**Re: Modification of Major Project Application 07\_0026 – Epiq Lennox (formerly known as Pacific Pines)**

Council has reviewed the documentation in relation to the Epiq Section 75W Modification No.5 and provide the following comments:

EPIQ LENNOX HEAD
ILLUSTRATION
C6 - MOVEMENT NETWORK
CLIENT: CLARENCE PROPERTY CORPORATION
LOCATION: LOT 234 DP1104071
LENNOX HEAD NSW

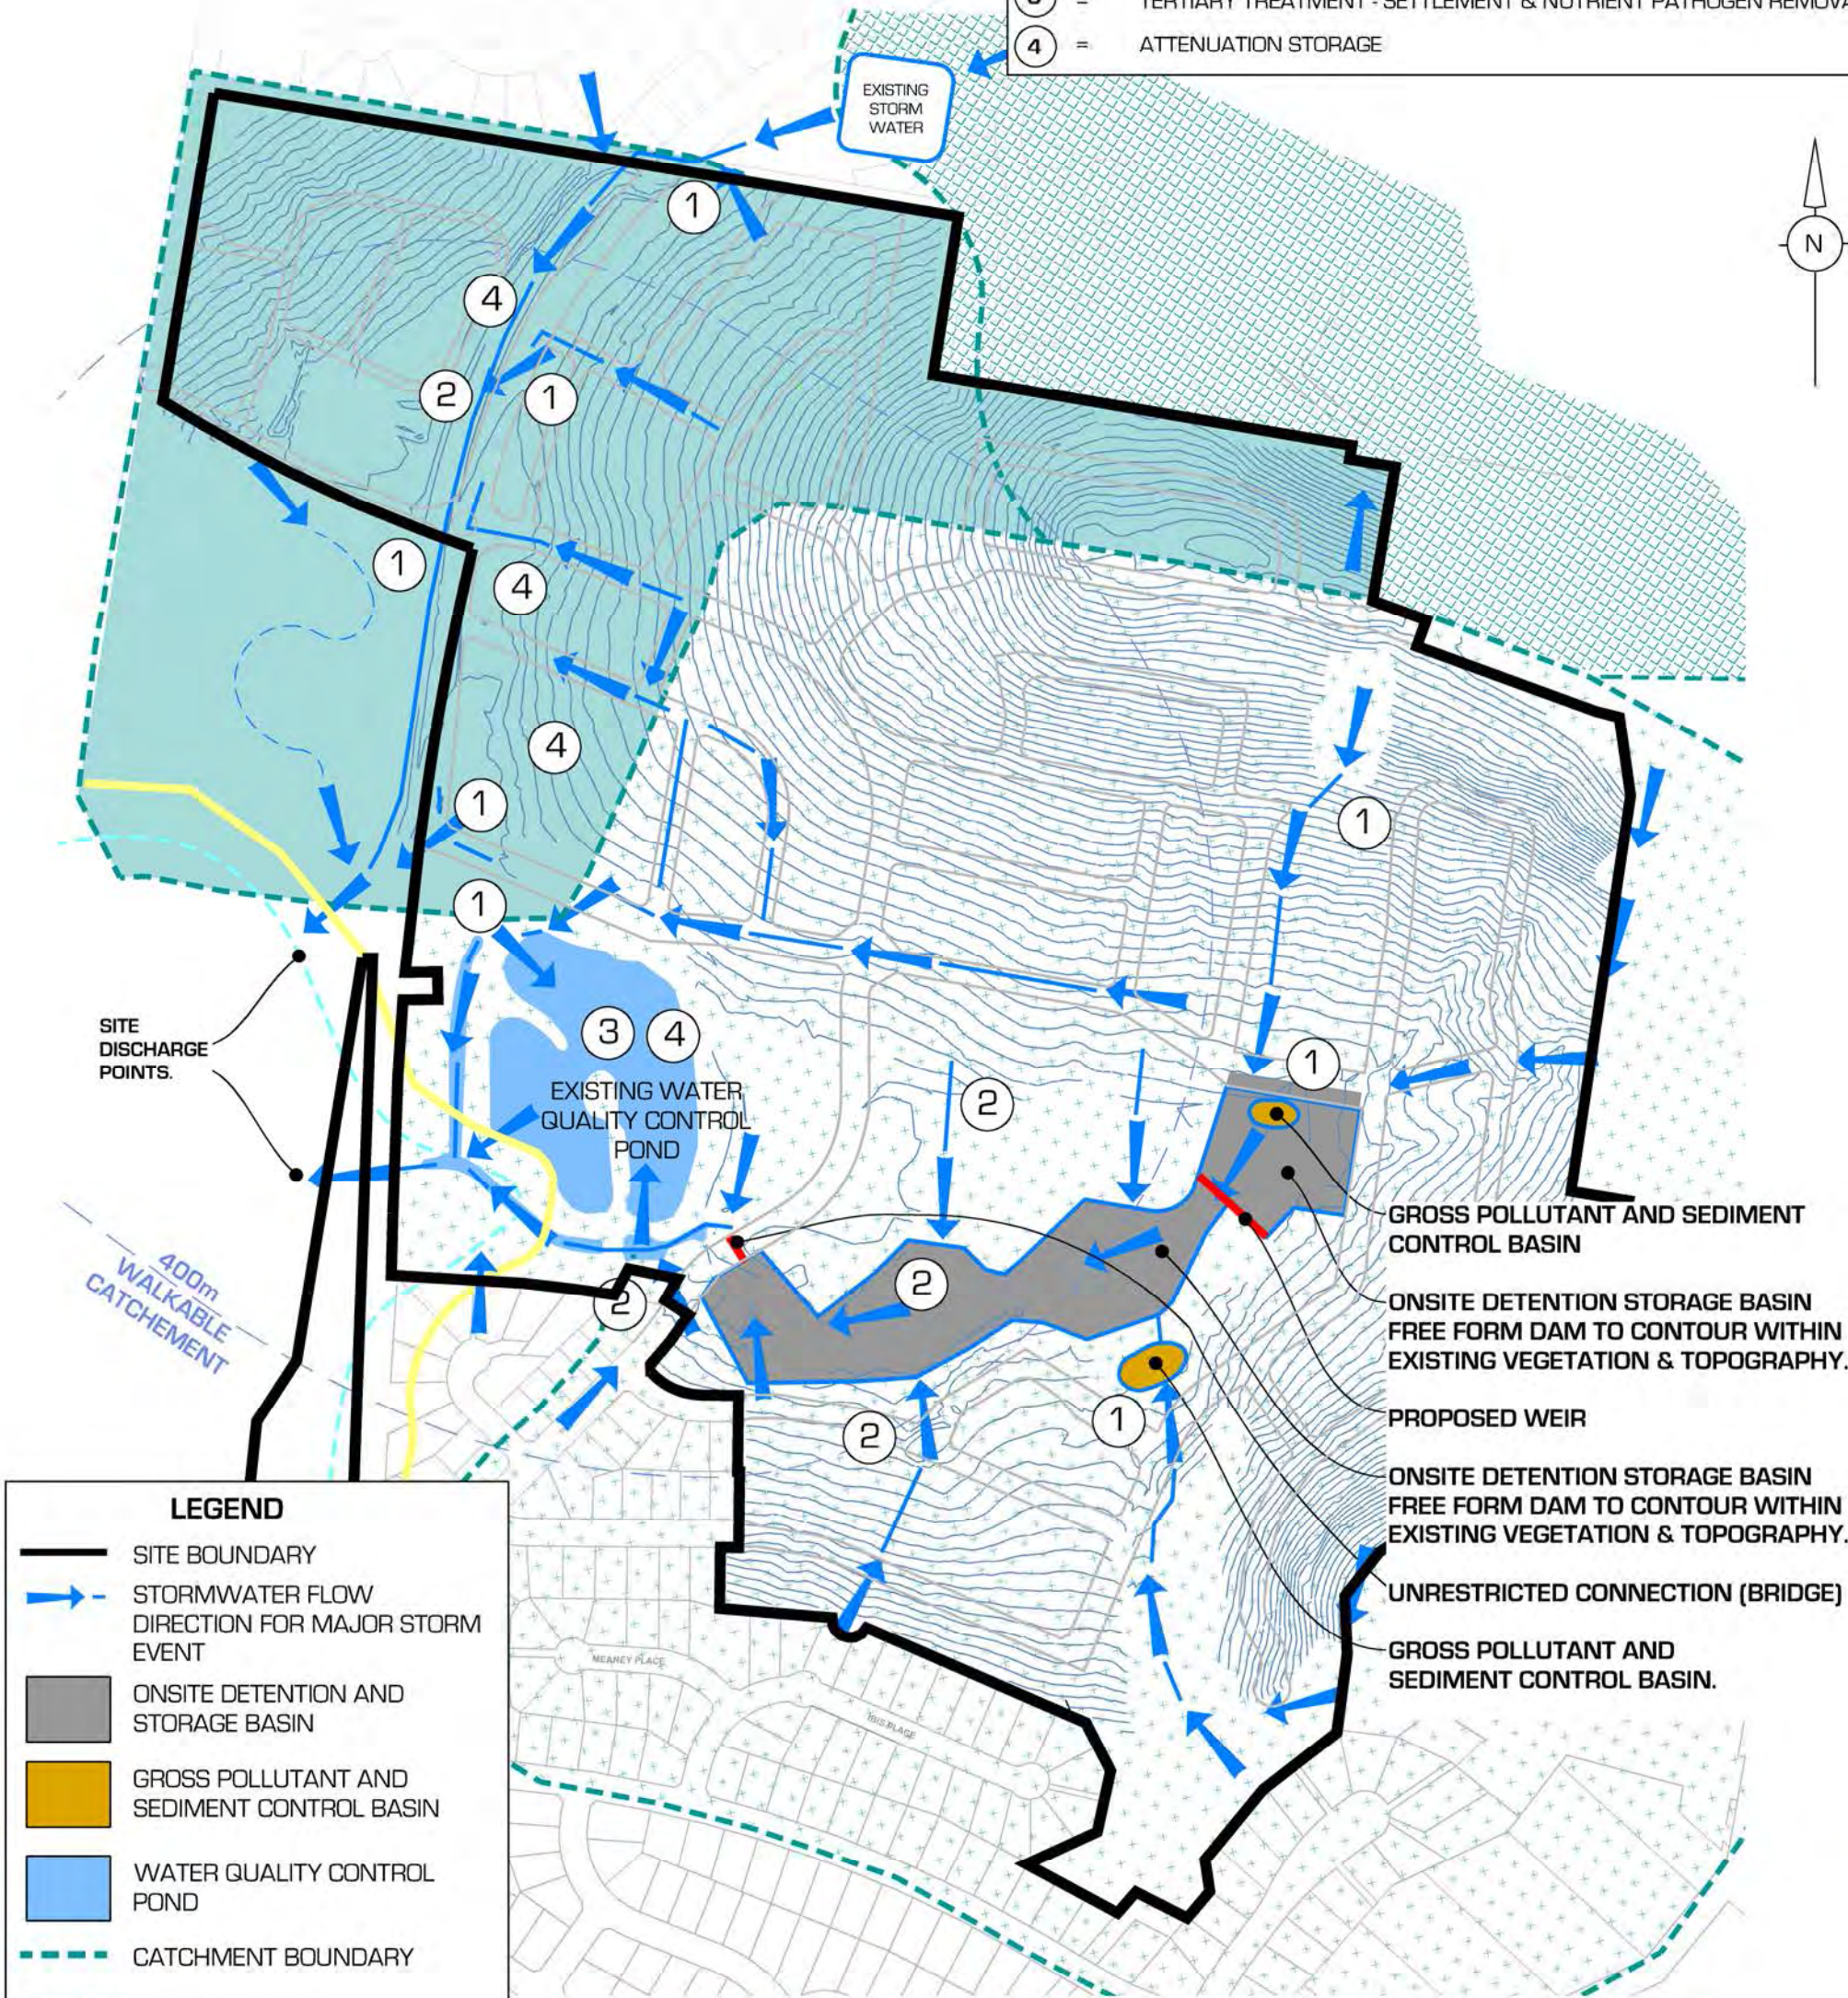
The Mod 5 proposed Movement Network is defined in "Illustration C6 Movement Network 16 November 2016" which is designated in proposed Concept Approval Term A3 and proposed Project Approval Condition A3.

The current (Mod 4) Illustration C6 has a legend that refers to classes of street specified as "Local Street a", Local Street b", Local Street c" and "Access Street" etc. However there is no explanation or reference in the Mod 4 approvals that defines what these terms mean.

The Mod 5 proposal for the "Illustration C6 Movement Network" legend still refers to SMEC street classes for the developed area and undeveloped areas in the supermarket precinct, Super Lot 7 and Super Lot 8, but designates "Northern Rivers Local Government Local Street" and "Northern Rivers Local Government Access" (these are classes of street

designated in the "Northern Rivers Local Government Development Design Manual") for the balance of the undeveloped area.

It is requested that the references to the unexhibited/unapproved SMEC plan should be deleted and the C6 legend should refer only to classes of street designated in the "Northern Rivers Local Government Development Design Manual".

Mod 5 proposed "Illustration C6 Movement Network", has a configuration that encourages a "rat run" that would compromise the intended road hierarchy and cause through traffic to short cut through residential local streets.

The potential "rat run" is created by the alignment of Montwood now being extended through a roundabout to the north of Main Street and following a north then westward unimpeded curvilinear path to the roundabout with Hutley Drive. Montwood Drive is the major (and only) external collector road connecting Pacific Pines/Epiq to the south and Hutley Drive is the major external connection to the north. The current road hierarchy has northbound traffic from Montwood Drive, turning left onto Main Street, proceeding westward on Main Street, then right onto Hutley Drive and then northward on Hutley Drive to exit the locality.

The undesirable attraction of the potential "rat run" could be reduced by introducing a number of forced T-intersections along its alignment that favour intersecting cross streets. The proponent has agreed to this arrangement which can be seen on attached Newton Denny Chappelle "Epiq Lennox Head Plan 4 Prop Layout Stages 2 & 6 Rev C - 5-12-16". In this plan the "rat run" is impeded by two T-intersections on the curvilinear residential street between Montwood Drive and Hutley Drive.

It is requested that the Mod 5 approval conditions require the insertion of two T-intersections in the local street curvilinear alignment connecting Montwood Drive and Hutley Drive as illustrated in Newton Denny Chappelle "Preliminary Road Network Sketch" dated 1-12-16 (attached).
